Our Ref: SB/SMP

Date: 30 April 2019

**TR010036 - A303 Sparkford to Ilchester Dualling Project - Examining Authority's Additional Written Questions**

***Question 3.8.1 Maintenance of Ponds***

A303 Sparkford to Ilchester Dualling Scheme TR010036

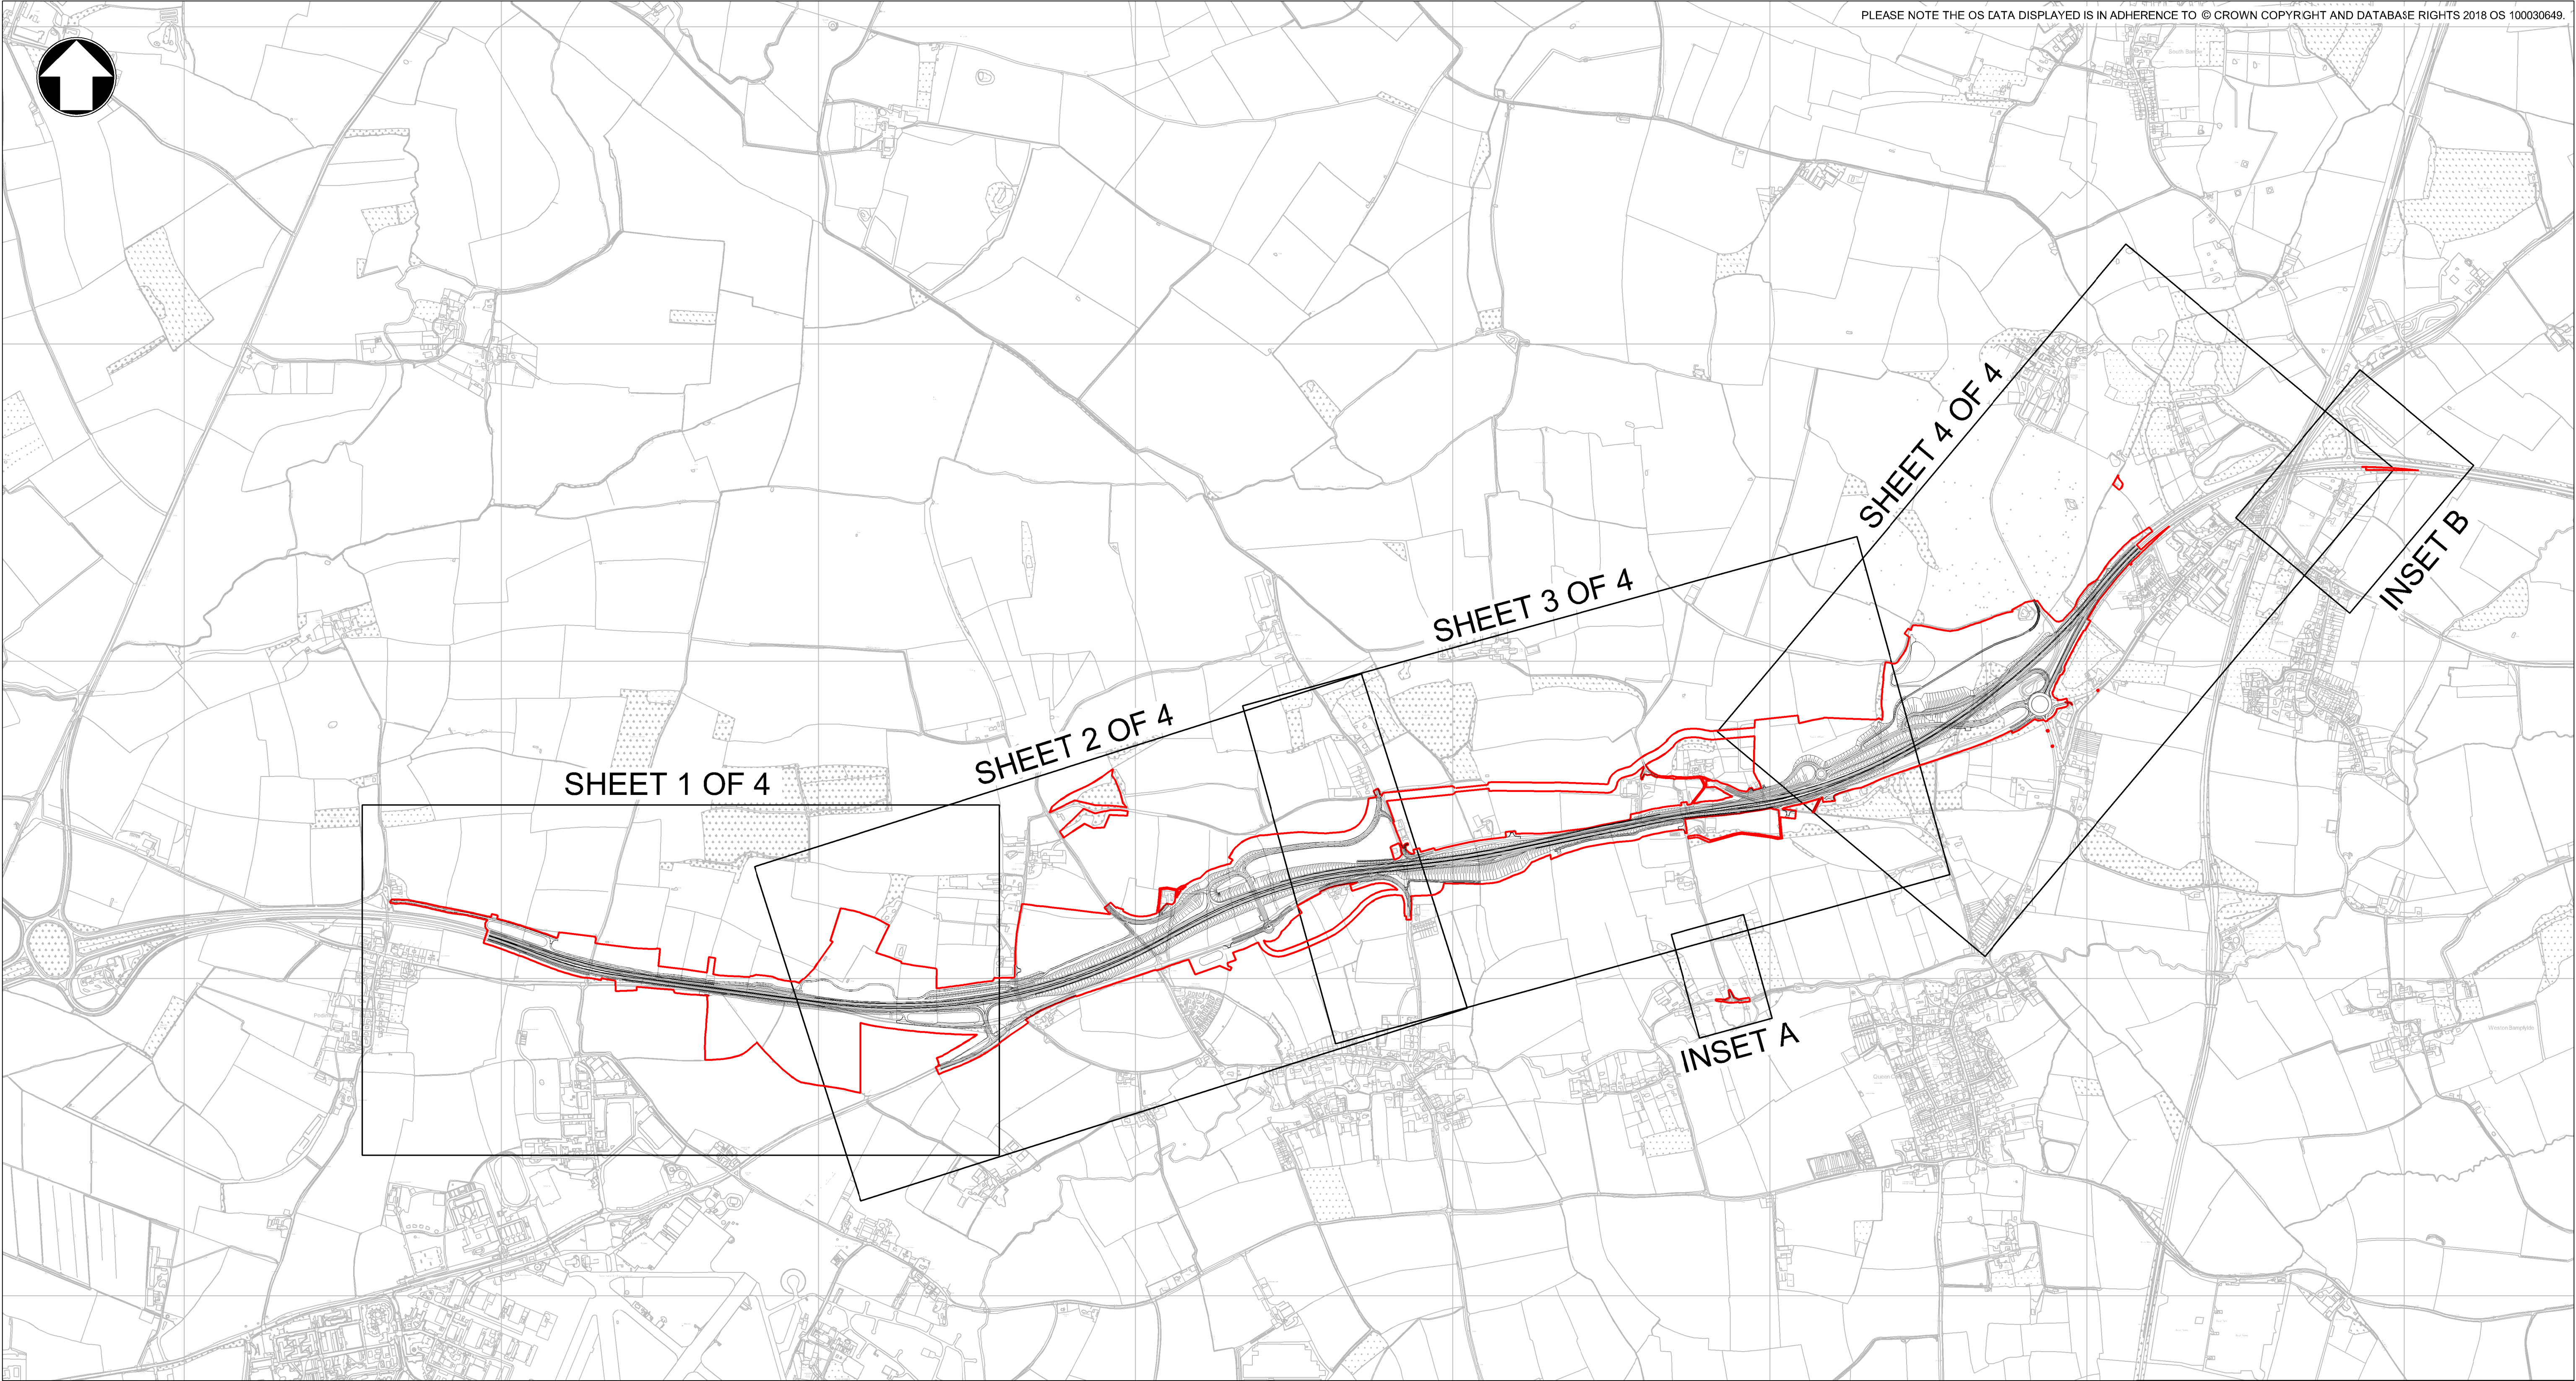
*In the Final SoCG between the Applicant and the Somerset Drainage Board Consortium [REP5-018] there is a dispute about the necessary width of any maintenance strips to allow for a full de-silt of the pond with the Consortium arguing for a greater than 4m strip.*

The Board is of the opinion that a minimum of 6m is required.

To operate safely the machine needs to be a minimum of 1.5m back from the edge of a pond or watercourse to ensure that there is no impact on the bank and a bank slip could potentially cause the machine to over-turn into the pond.

The machine width is around 2.5m wide and when the cab turns there is an overhang of 1m for the counterweight as can be seen below:

A safe working area of 1m should be left behind the counterweight. This adds up as:

**This equals 6m**

If the maintenance strip is only 4m wide a standard machine would not be able to safely operate and the task would be more complicated, more expensive and would be less likely to happen. This could mean a reduction in the volume of storage available in the pond which would increase flood risk.
